CITY OF ALBUQUERQUE

RE: **Matheson Park Elementary School Site Improvements** **H21-D036**
4410 Irving Blvd. NW PE Stamp: 4/22/2013
Grade & Drain Plan for Grading, Paving and SO-19 Permits

Based upon the information provided in your submittal received 05-16-2013, the above referenced plan cannot be approved for Grading, Paving or an SO-19 Permit.

CHANNEL
PENETRATION
DETAILS

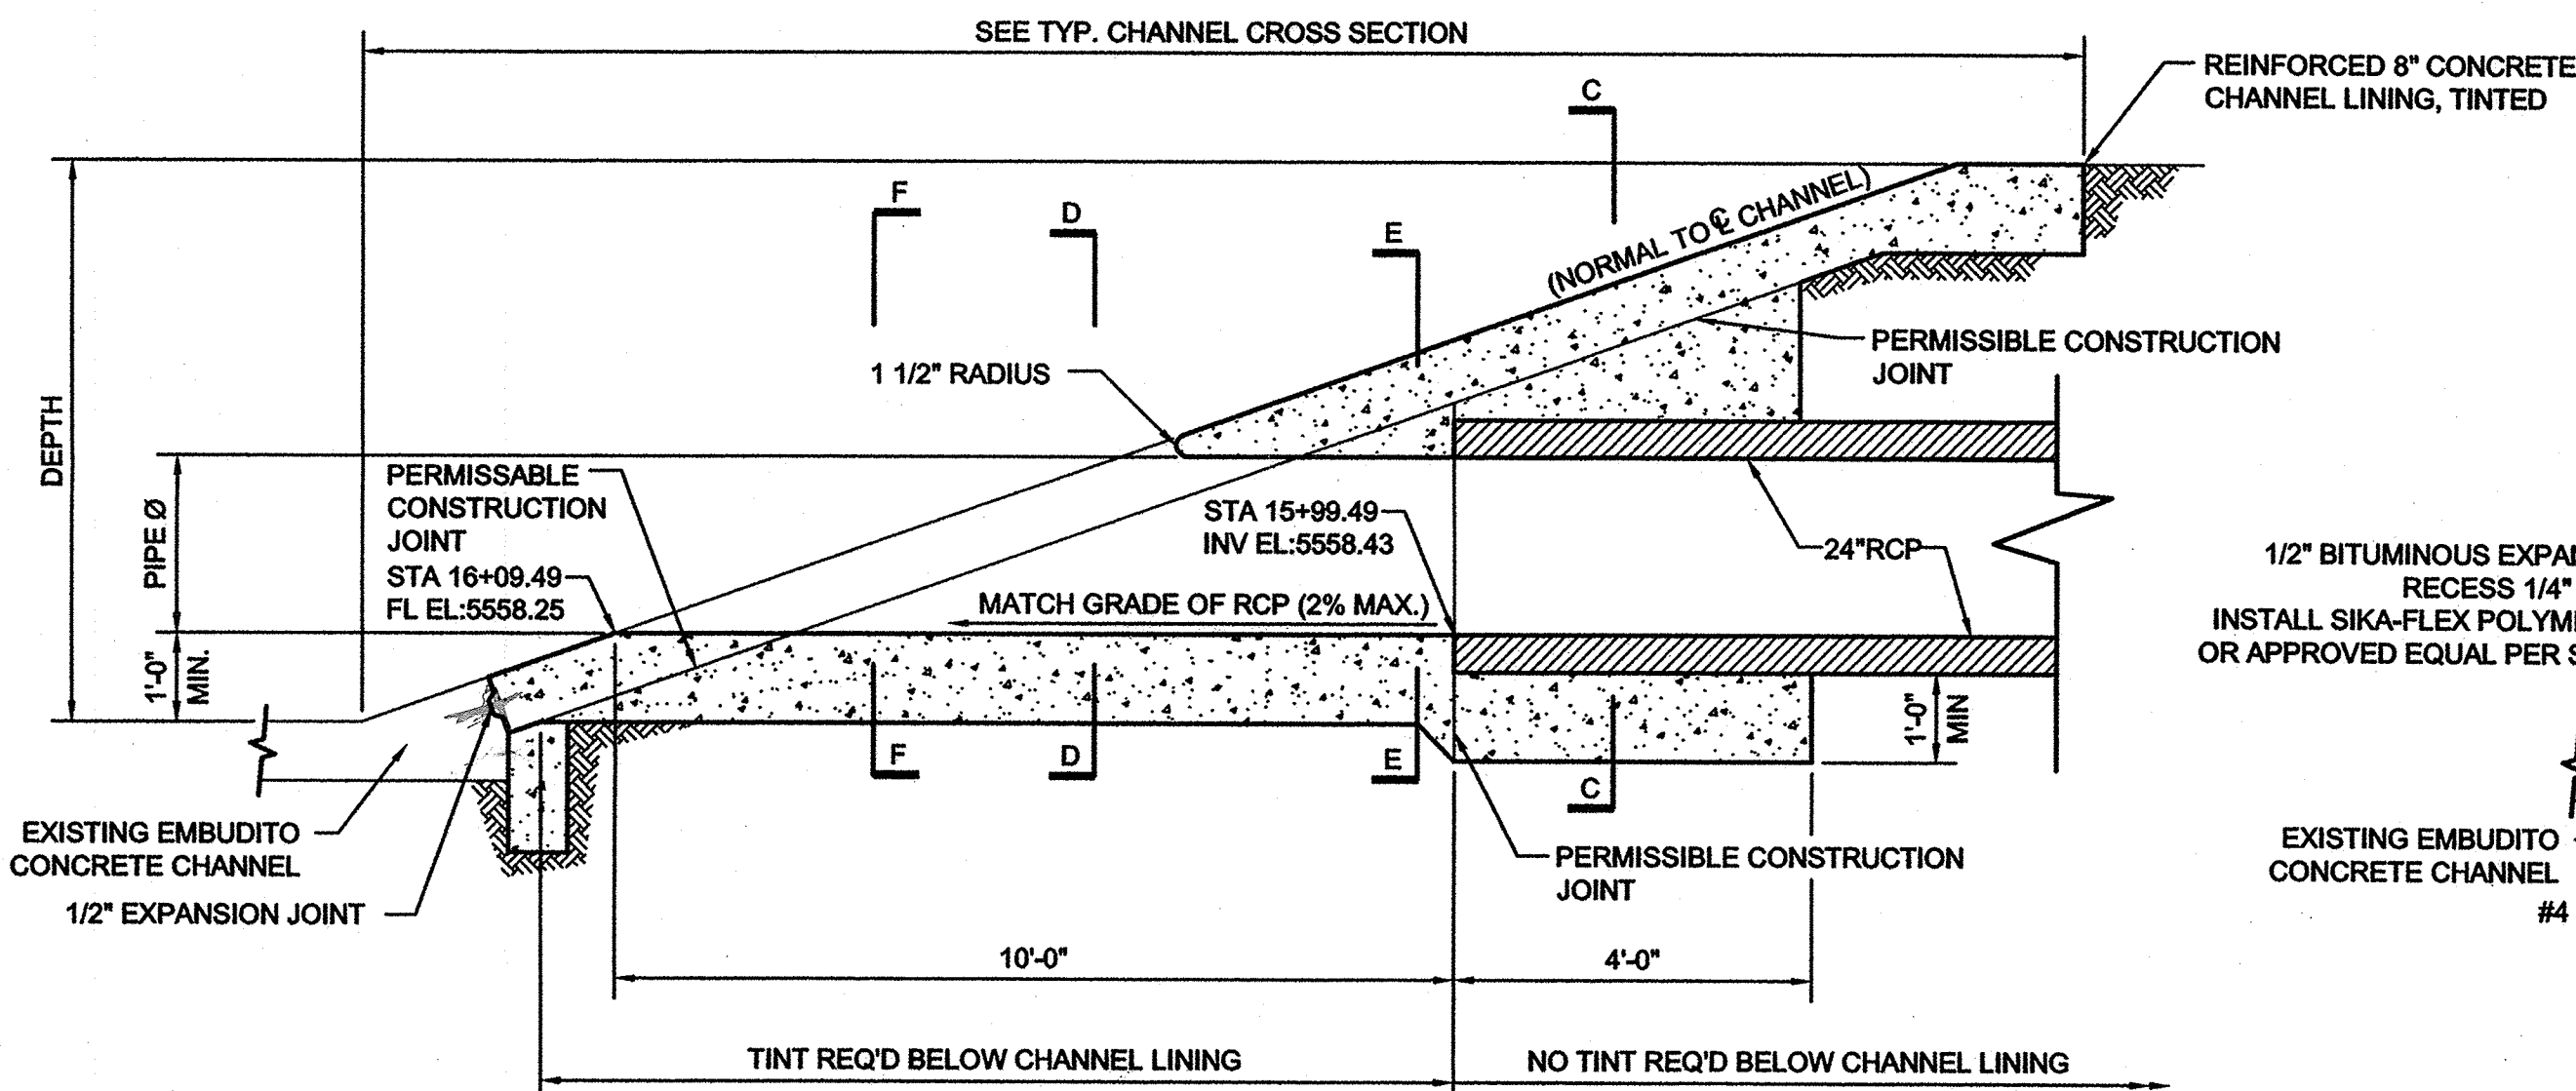
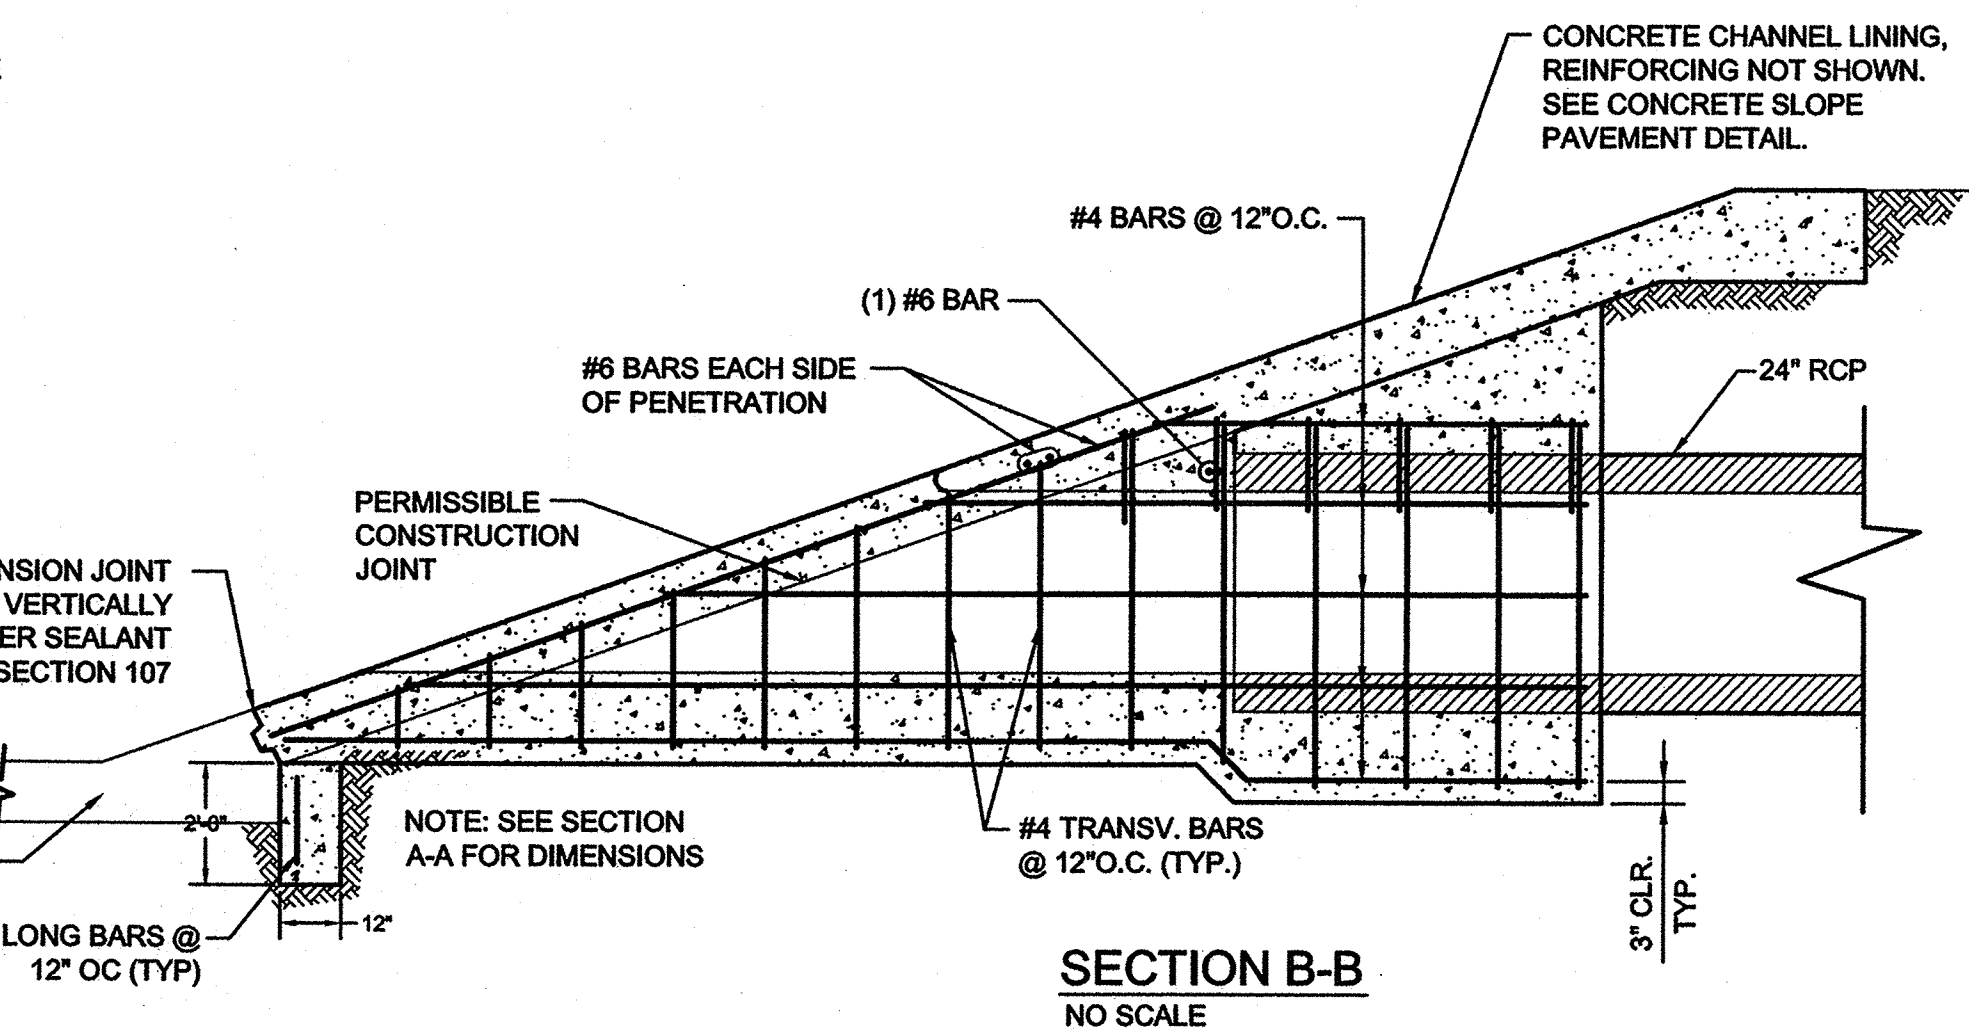
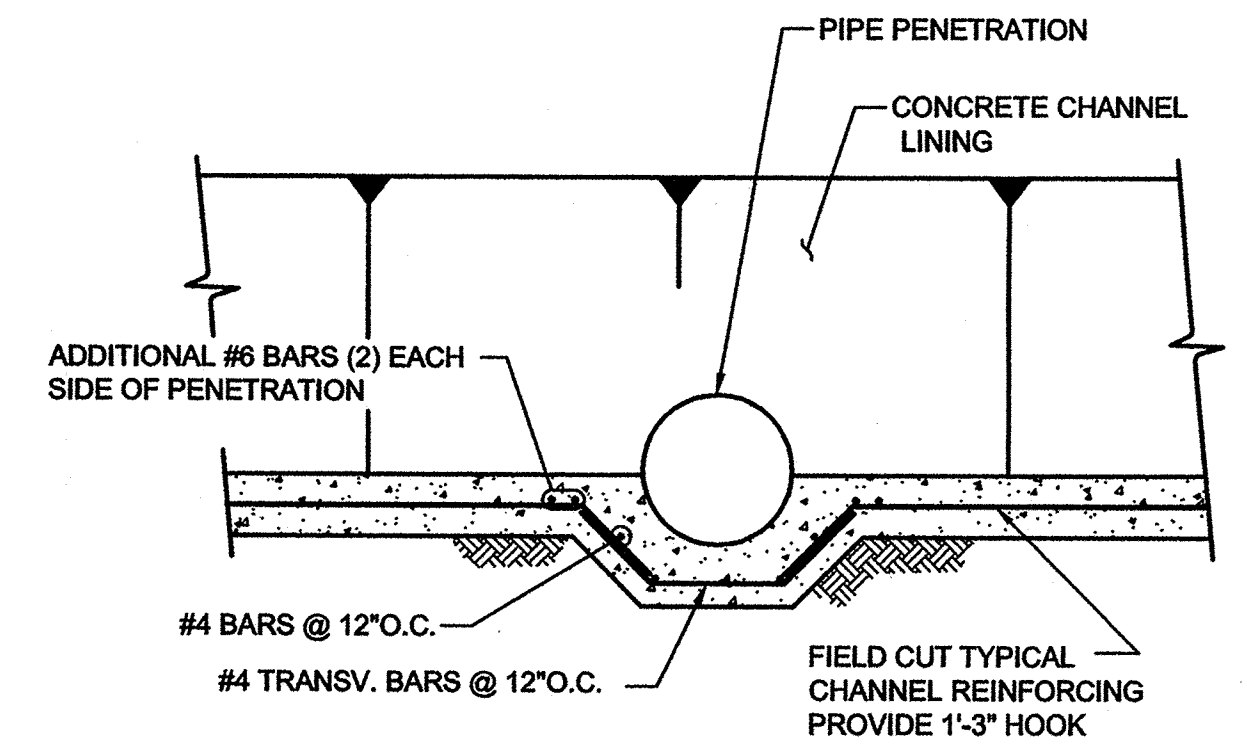
13. C-103: Key Note 1 refers to Detail A1, which is not found on C-502.
14. C-102: Key Note 5 refers to a Channel Penetration detail not found on C-502.
